Item No. **Report of the Head of Development Management and Building Control**

Address: 5-7 HERCIES ROAD HILLINGDON

Development: Change of use from Use Class E to mixed use of Class E and Sui Generis (Massage and Beauty Shop) and merging shop nos. 5-7 & 9-11 into one single unit.

LBH Ref Nos: **78371/APP/2023/3322**

@ISO A3 (297 x 420)	
DRAWN: SC	DRAWING NUMBER	REV.
SCALE: AS SHOWN	2023-5-7HR-PL-1	1.0A
DATE: 21/12/2023	SHEET: # 1 / 2

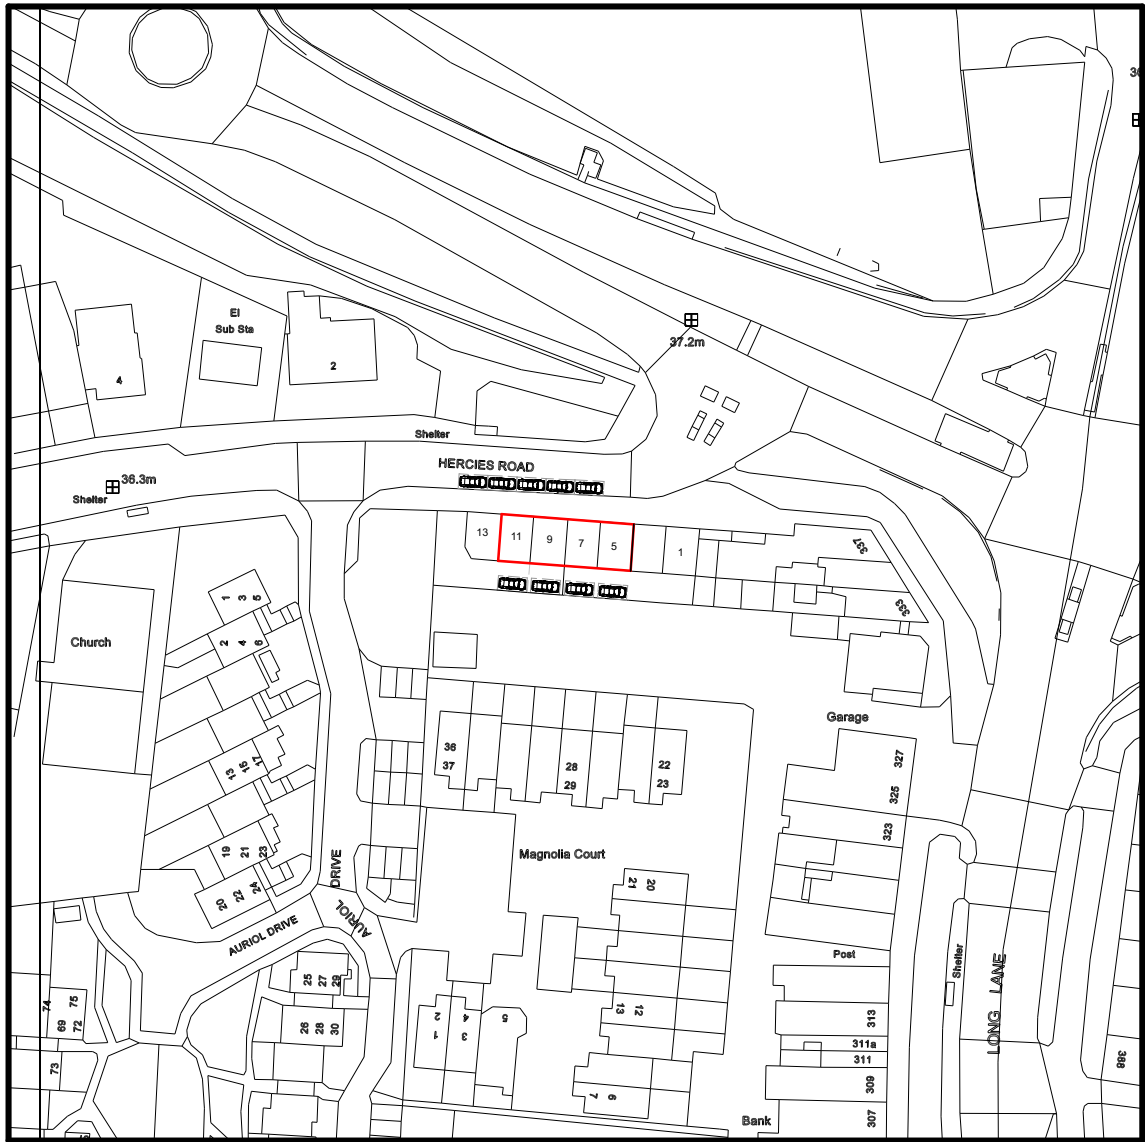
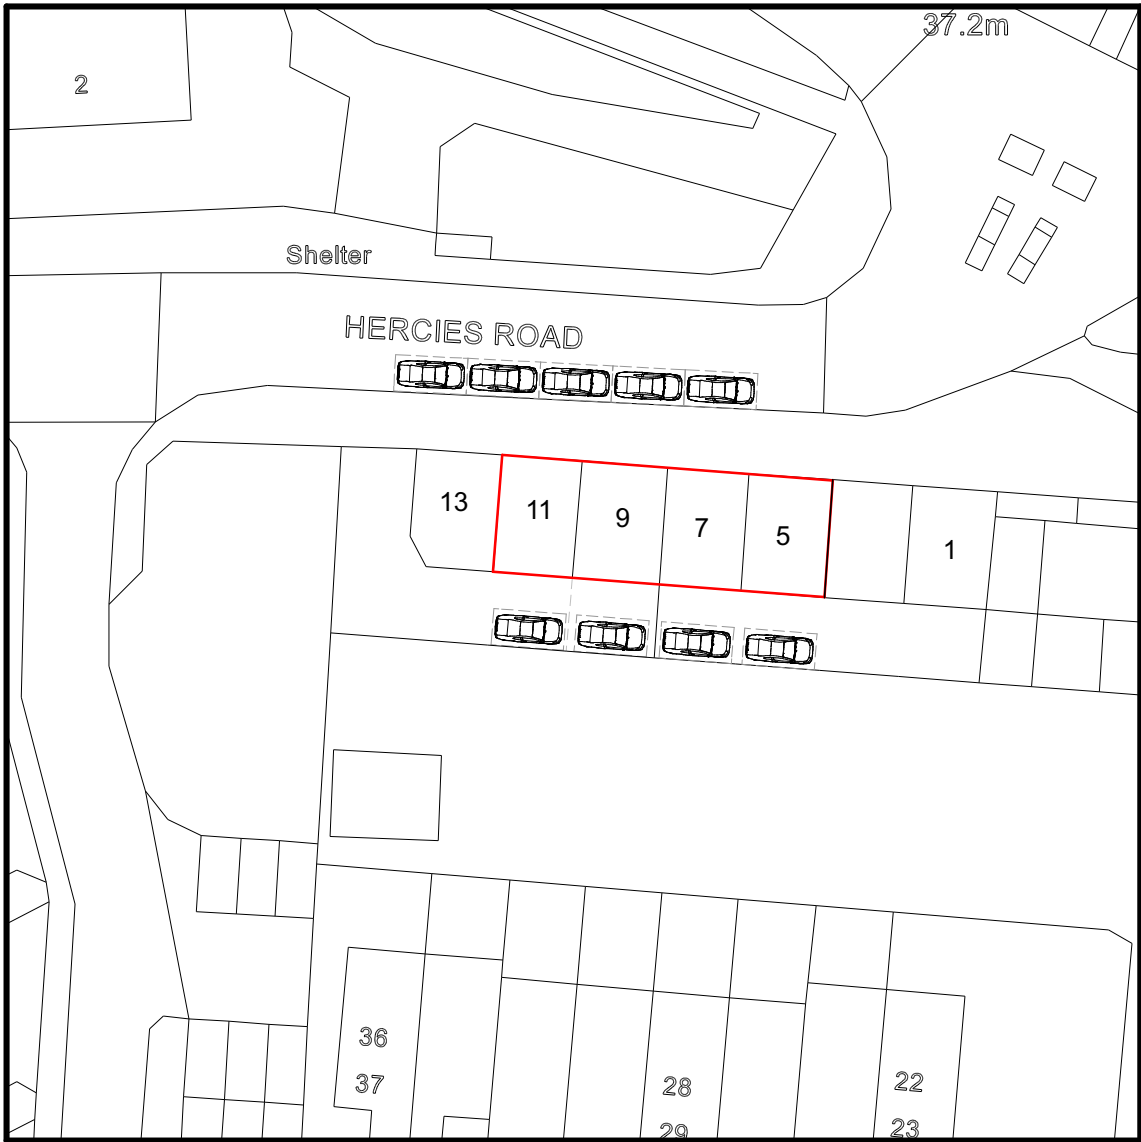
Drawing 2023-5-7HR-PL-1 Rev 1.0A titled Site Plan shows the Location Plan and Site Plan which demonstrates access between the site and the adopted highway, however, a blue line should be provided around 9 and 11 Hercies Road as this would be considered land owned by the applicant adjacent to the application site as detailed within Government guidance which states that;

The application site should be edged clearly with a red line on the location plan. It should include all land necessary to carry out the proposed development (eg land required for access to the site from a public highway, visibility splays, landscaping, car parking and open areas around buildings). A blue line should be drawn around any other land owned by the applicant, close to or adjoining the application site. (Retrieved from Making an application - GOV.UK (www.gov.uk)).

As the proposed change of use relates to both units 5-7 and 9-11 Hercies Road, the red outline around both units is correct.
